STATUTORY PLANNING CONSULTATION RESPONSE

Application Number:	3/2026/0214
Proposal:	Proposed erection of 26 affordable dwellings with associated access, gardens, parking and landscaping.
Location:	Land at Albany Drive Copster Green BB1 9EH

The Lead Local Flood Authority **withdraws its objection** to the above application as further information has been submitted in response to the Lead Local Flood Authority's objection. The application will be considered acceptable subject to the inclusion of the below recommended condition(s), in consultation with the Lead Local Flood Authority:

Impermeable Area & Flood Route Plan

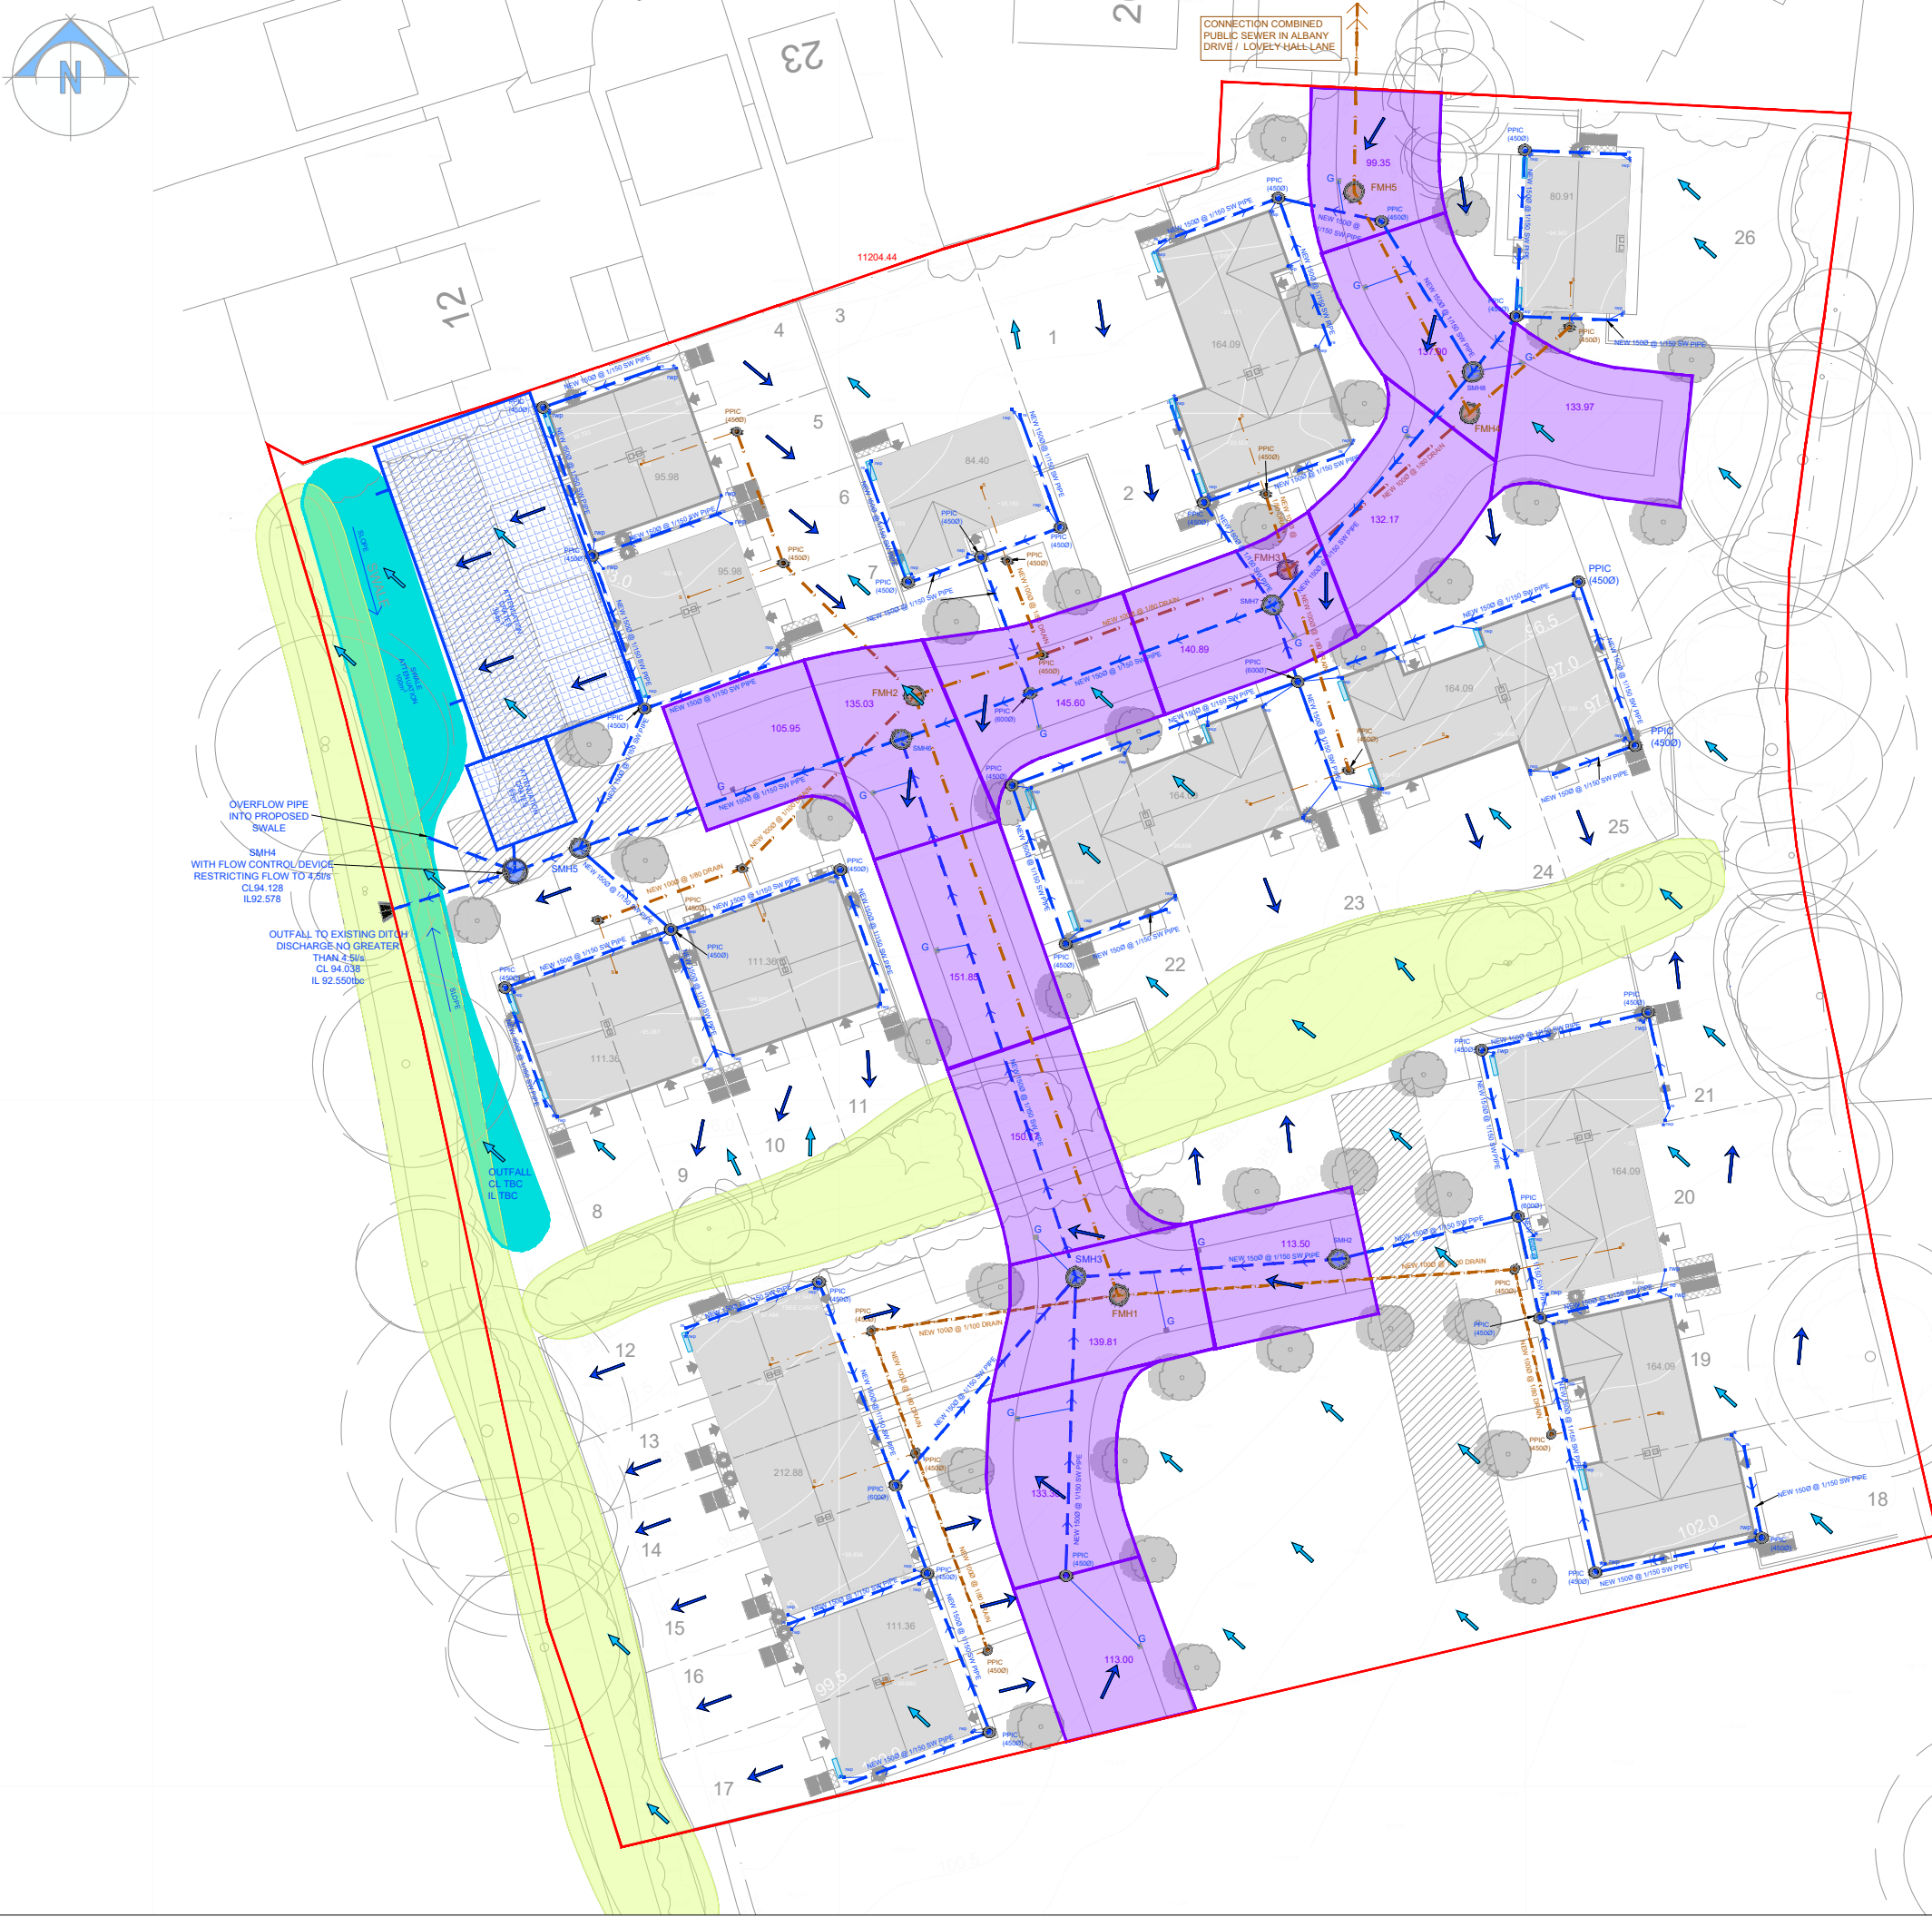
- The applicant will be expected to provide evidence of how the storage volumes have been derived based on the proposed discharge rate of 4.5l/s as well as evidence which demonstrates how the discharge rate of 4.5l/s has been calculated based on an appropriate contributing area at the detailed design stage.
- There may be some areas like the proposed swale which will contribute to the drainage system, in which case these areas should be included in the contributing area.
